From: [Kelman, Gordon - E&E](#)
To: [John Hayden](#)
Cc: [Guled Warsama](#)
Subject: RE: JDE site , Banbury, Proposed culvert
Date: 18 July 2017 11:52:07
Attachments: [image001.gif](#)
[image002.gif](#)
[image003.png](#)
[image004.jpg](#)

From: John Hayden [mailto:JohnHayden@hydrock.com]
Sent: 17 July 2017 16:09
To: Kelman, Gordon - E&E
Cc: Guled Warsama
Subject: JDE site , Banbury, Proposed culvert

Drawing Number: **C161279-HYD-XX-XX-DR-C-0102**, Revision: **T4**

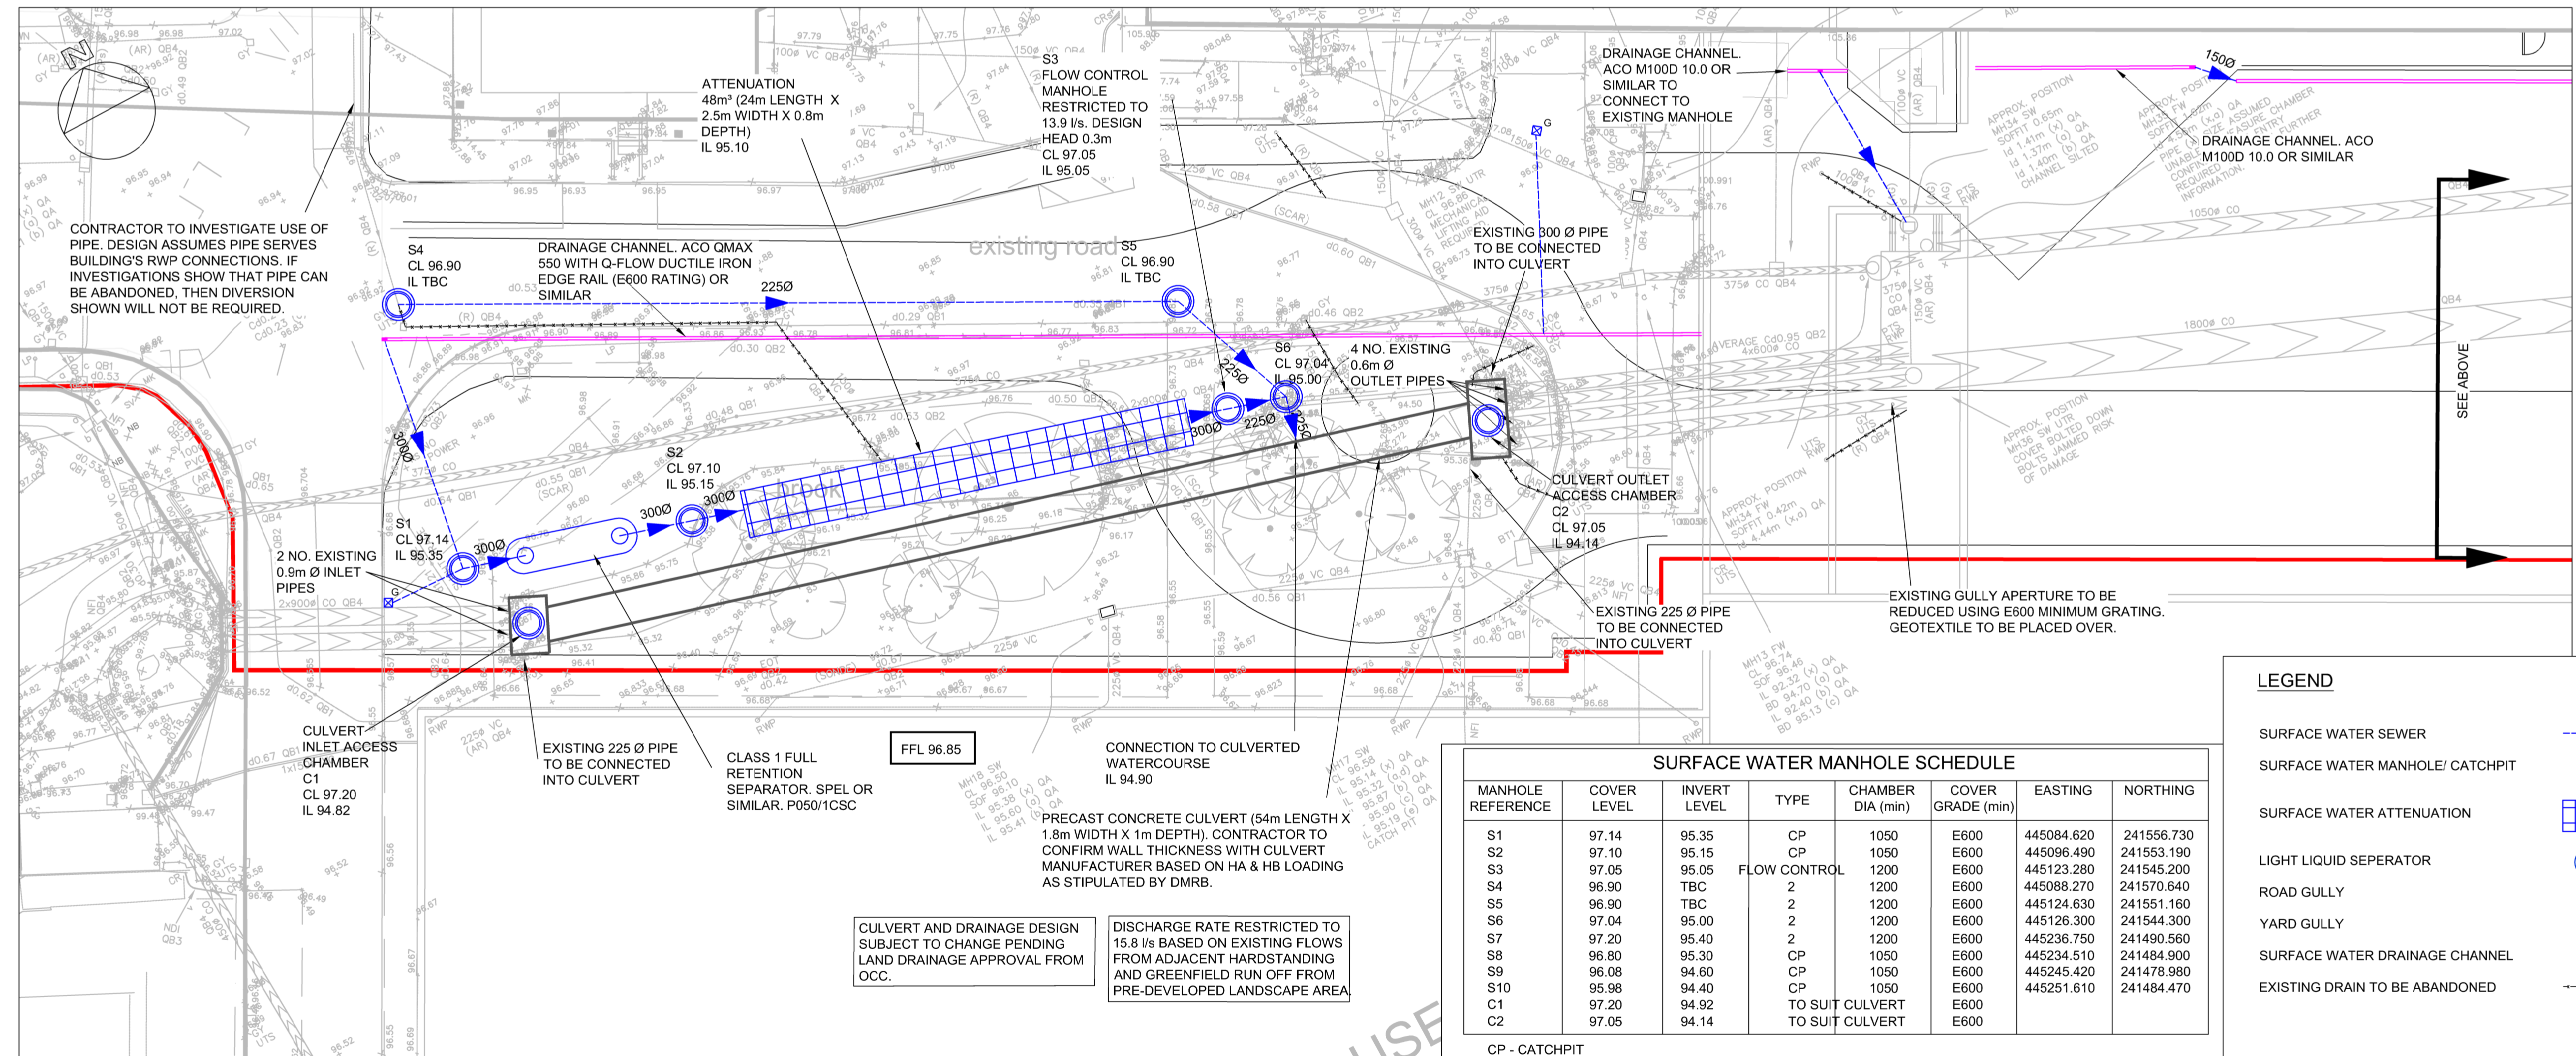
In reference to the 4 pipes, yes, I agree that additional capacity would be preferred from our point of view as the existing open watercourse being culverted would provide that extra volume capacity and have no detrimental effect up stream.

As a result of culverting this section of Birds Brook the impermeable area shall increase by approximately 1100m². We would propose to drain this area (Area B) to the culvert at a restricted rate - greenfield run off for this small area shall be less than 5l/s. We would therefore propose to drain it at 5l/s which is generally recognised as the minimum rate.

It is proposed that the surface water from the parking/ throughway areas shall drain to the culvert via interceptors.

We are proposing to base the culvert design on the capacity of the two incoming 900 dia pipes (3.4m³/s) . We recognise that the 4 downstream pipes restrict the outgoing flow (capacity 1.8m³/s). Additional capacity may therefore be required within the proposed culvert to allow the water to back up in this area as I suspect it does at the moment.

In principal this looks ok to me from a Land Drainage consenting point of view. Subject to culvert design and construction / installation method statements.
